RE: Permit Application No. 2005-146
Project Name: Rudolf Residence
Project Address: 8253 W Mercer Way, Mercer Island, WA 98040

This letter is in response to the building review comment on page A9 of the drawings. Our response appears in **bold**.

A9

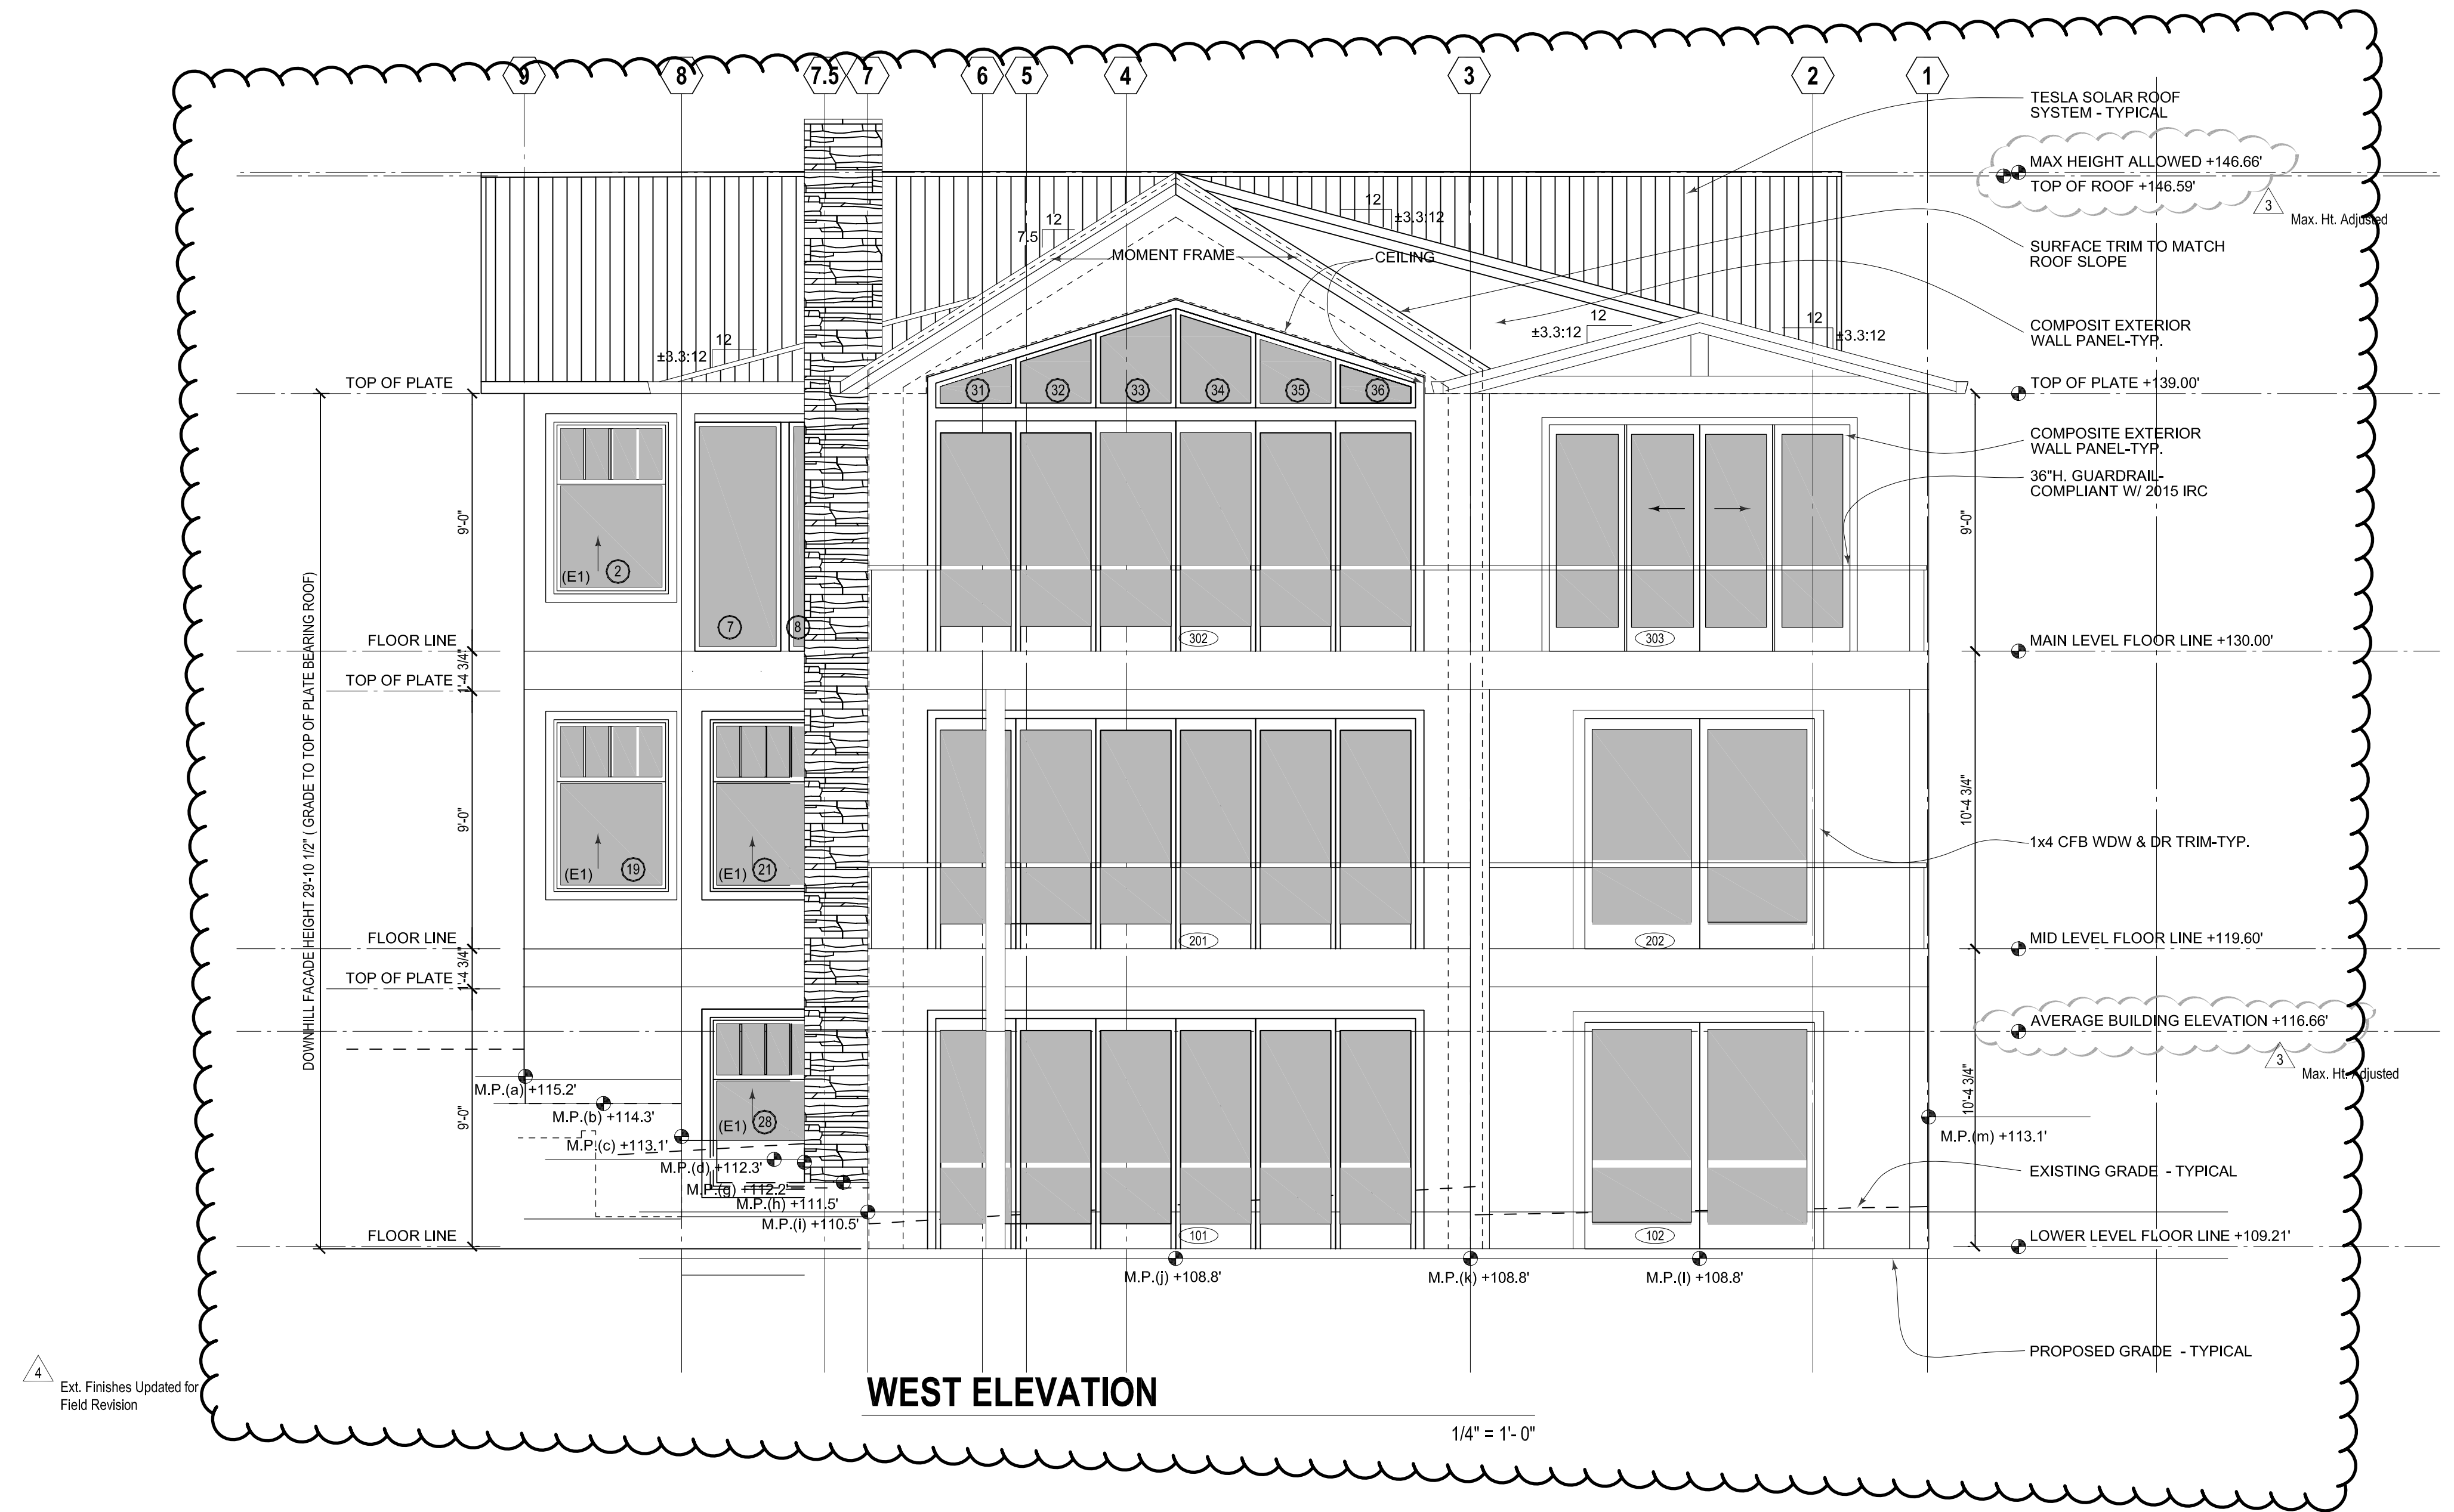
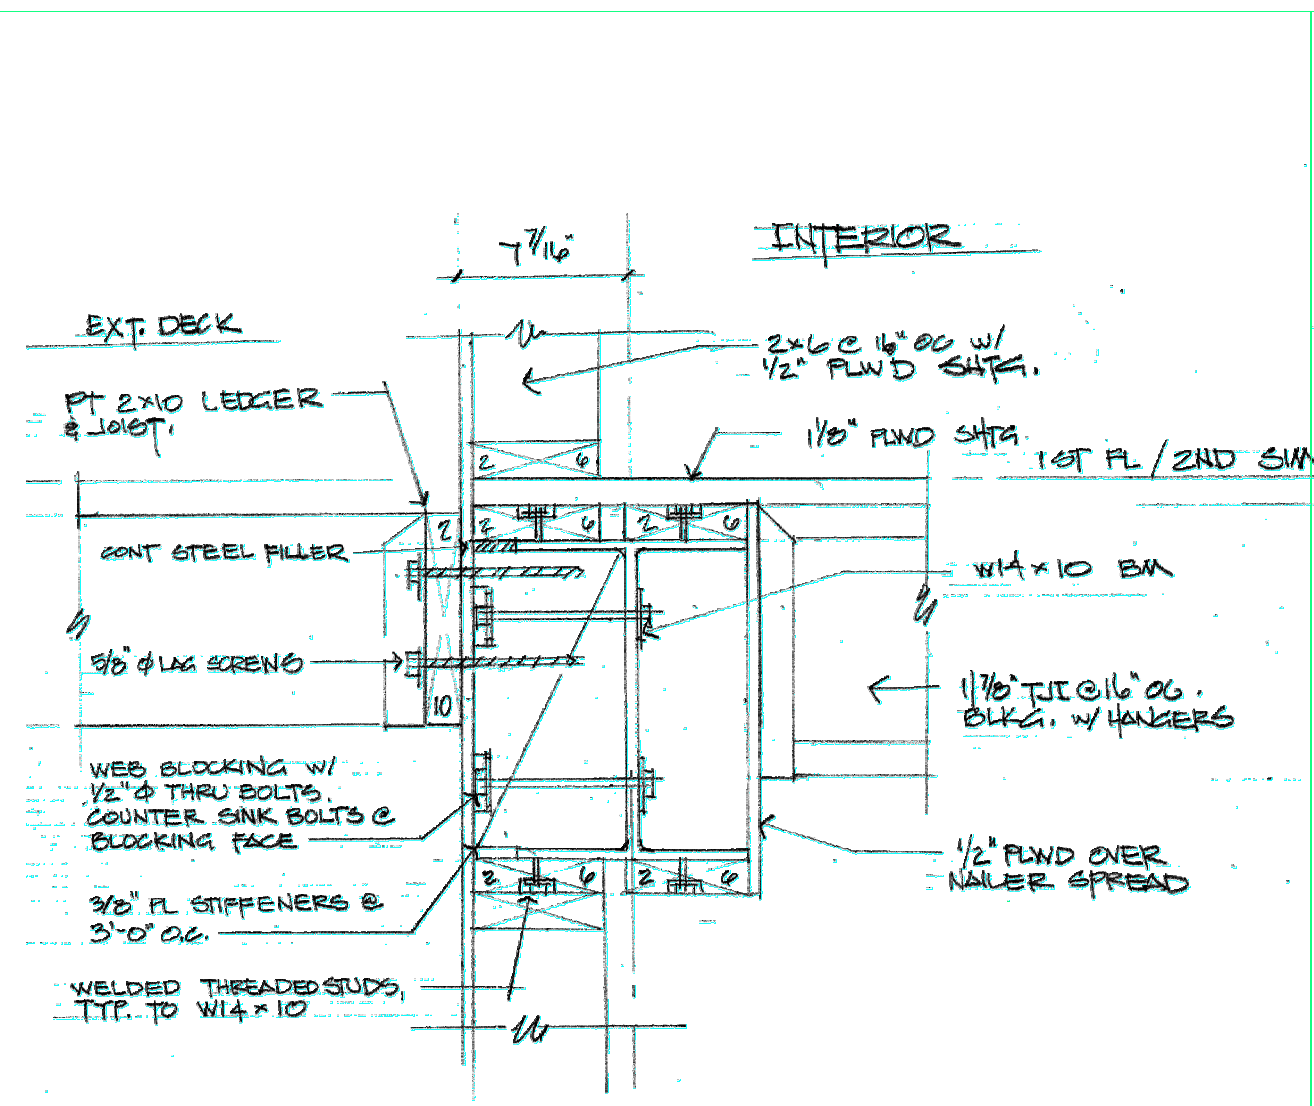
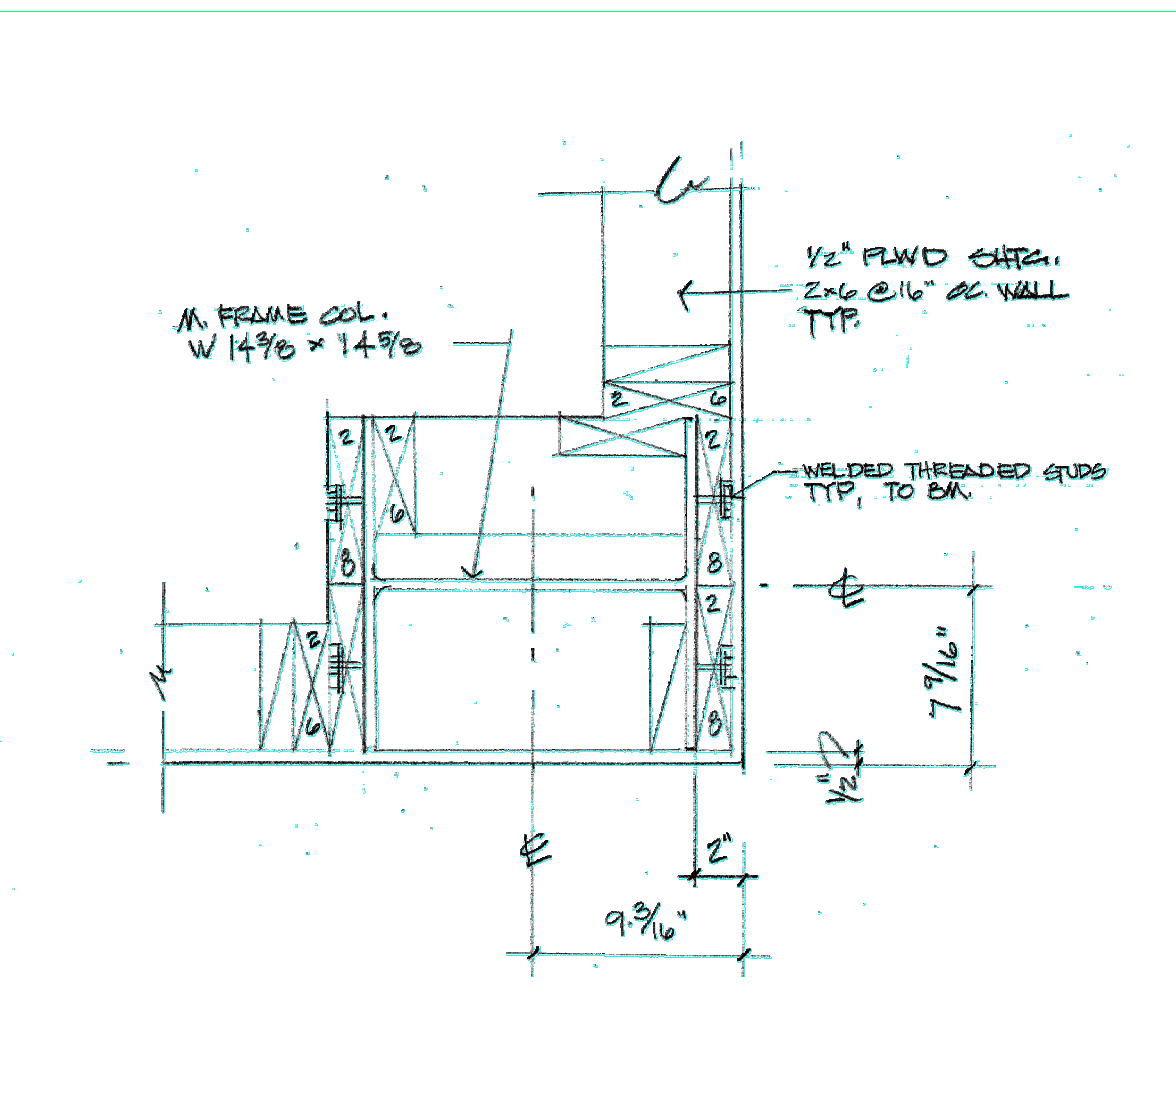
Structural calculations dated 3/4/22 refer to a roof structure weighing 15 psf. Please coordinate with structural for the actual roof assembly dead load considering the photovoltaic system and any special ceiling systems.

We have coordinated with the architect regarding the roof and wall assemblies and have confirmed that they are still of equal or lesser weight than we assumed in our structural calculations. Please note that the owner has elected not to install the photovoltaic system. The wall assembly will be fiber cement board over rain screen over WRB over ½" plywood over 2x6 studs with R21 insulation with vapor retarder and ½" GWB. The roof assembly will be standing seam metal roof over 5/8" plywood with batt insulation and ½" GWB ceiling.
